From: Evan Maxim
Sent: Tuesday, June 5, 2018 5:13 PM
Cc: Andrea Larson; pnrmerc@comcast.net
Subject: FW: Comments on SJCC Expansion Proposal

From: pnrmerc@comcast.net <pnrmerc@comcast.net>
Sent: Tuesday, June 5, 2018 1:35 PM
To: Evan Maxim <evan.maxim@mercergov.org>
Cc: sabrinachang@gmail.com
Subject: Comments on SJCC Expansion Proposal
Importance: High

I have two comments:

Illustrative Site Plan

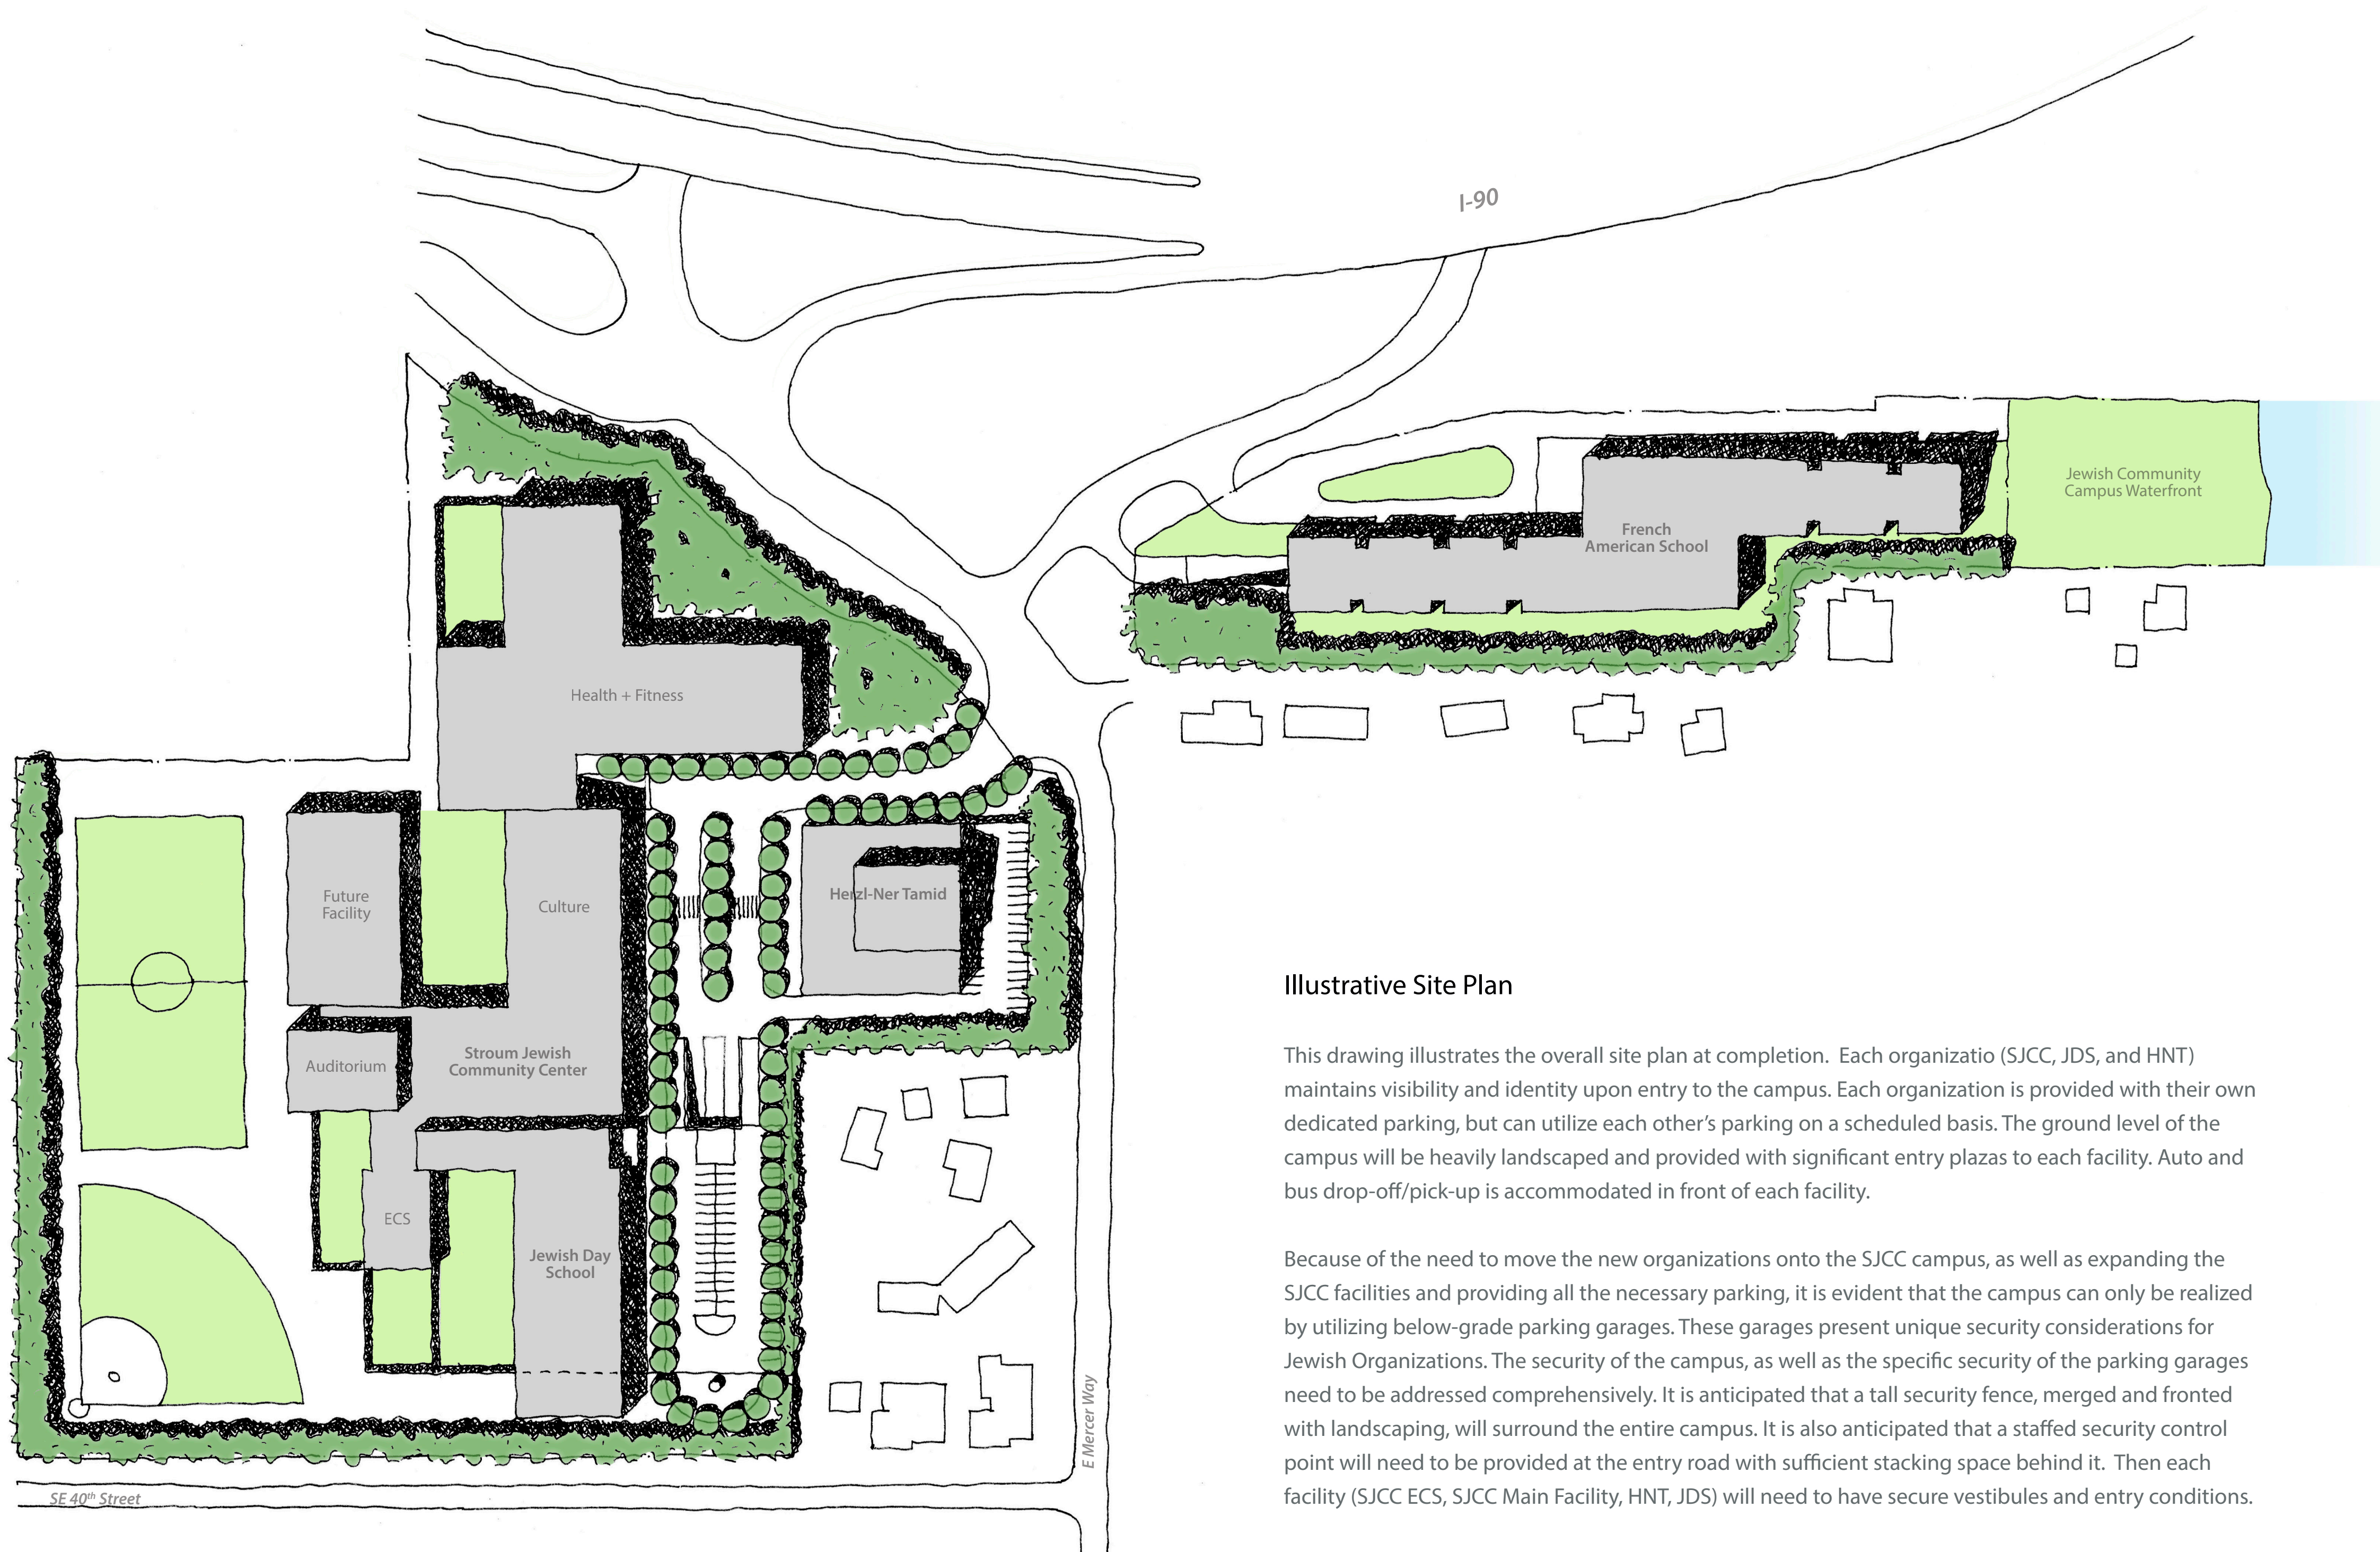
O The proposed layout of the referenced project shows that under the plan the house at 9975 99th Ave SE is to be purchased. What about the dwelling at 9985th 99th Ave SE? Already purchased? Given the city's current financial situation, does it make sense to lose two more taxable properties? Also, what would be the status of 99th Ave SE itself. That private road services homes at 9900, 9910, 9920, and 9930 99th Ave SE.

O As a retired Army officer, the heavy reliance on a forested "high" fence to provide protection for persons using and in the underground parking facilities seems overly optimistic. Obstacles are in general susceptible to being penetrated. Thus, an effective obstacle requires careful monitoring and defending by a sufficient and well-trained force of security personnel. Think of films like "Mission Impossible".
